Ribble Valley Borough Council
Council Offices
Church Walk,
Clitheroe
Lancashire
BB7 2RA

Phone: 0300 123 6780
Email: Kathryn.Walsh@lancashire.gov.uk
Your ref: 3/2025/0147
Our ref: 3/2025/0147/HDC/KW
Date: 16 April 2025

Location: Peel Street Business Estate Peel Street Clitheroe BB7 1RA
Proposal: Proposed demolition of existing buildings and erection of six 2-bed and one three-bed apartment building together with a two storey business centre and associated parking and bin store.
Grid Ref: 374509 441572

**Swept Path Analysis and Visibility
Splay Drawing**

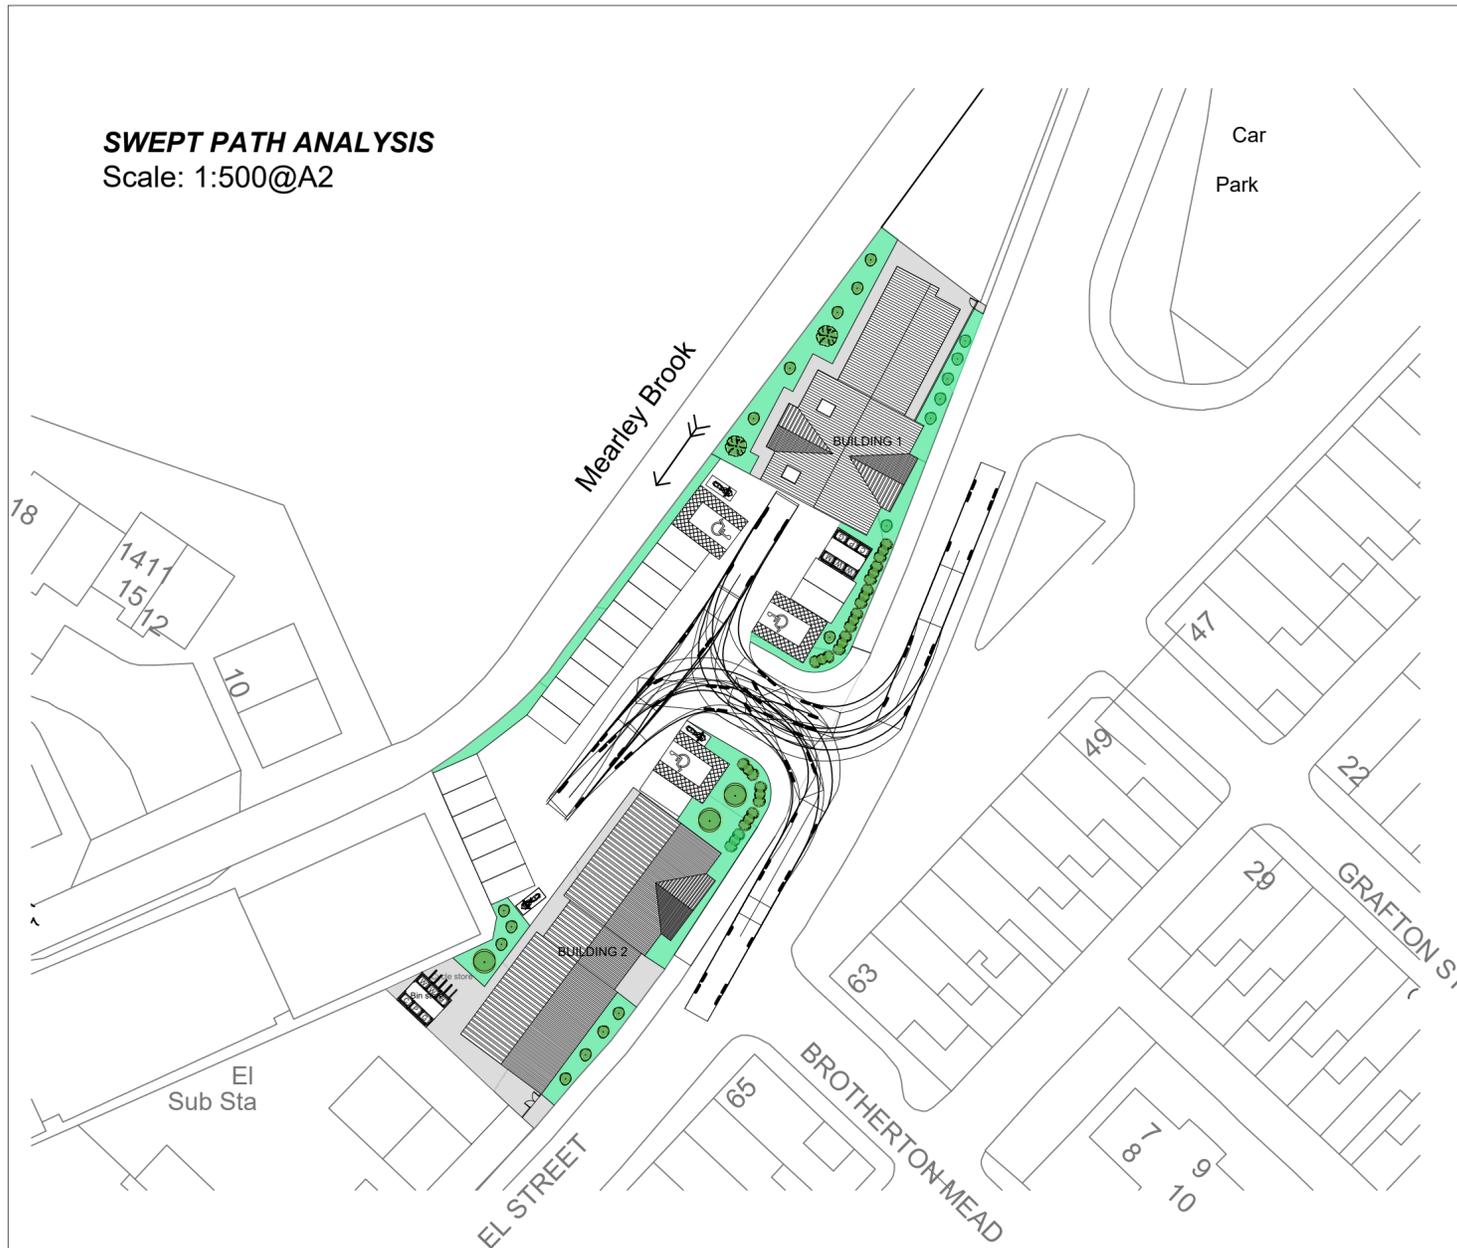
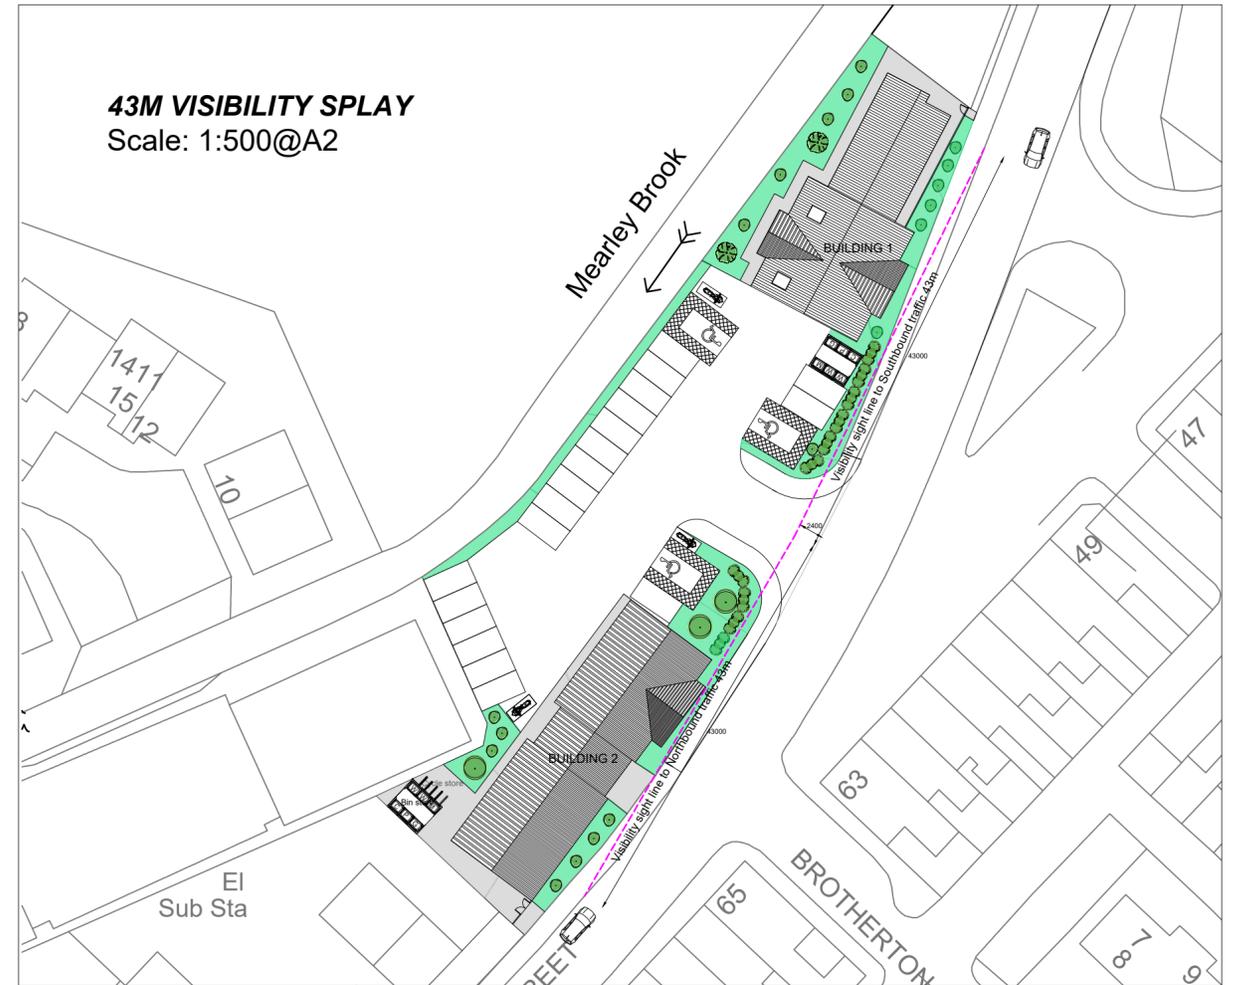
However, the applicant has not provided a swept path drawing to show that the access is appropriate for the type of vehicles that will be required to access the site such as a bin wagon as such the LHA require a swept path drawing showing the largest vehicle expected to use the access, entering, turning within and exiting the site.

After further reviewing the site access, the LHA also require a vehicular visibility splay drawing to be provided. The LHA require vehicular visibility splays of 2.4m x 43m to be provided in both directions. Should the proposed access not be able to achieve this minimum requirement, a speed survey should be undertaken within the vicinity of the site access demonstrating the 85th percentile speeds along Peel Street. The speed survey should then be complemented with a vehicular visibility splay drawing which should be submitted to the LHA.
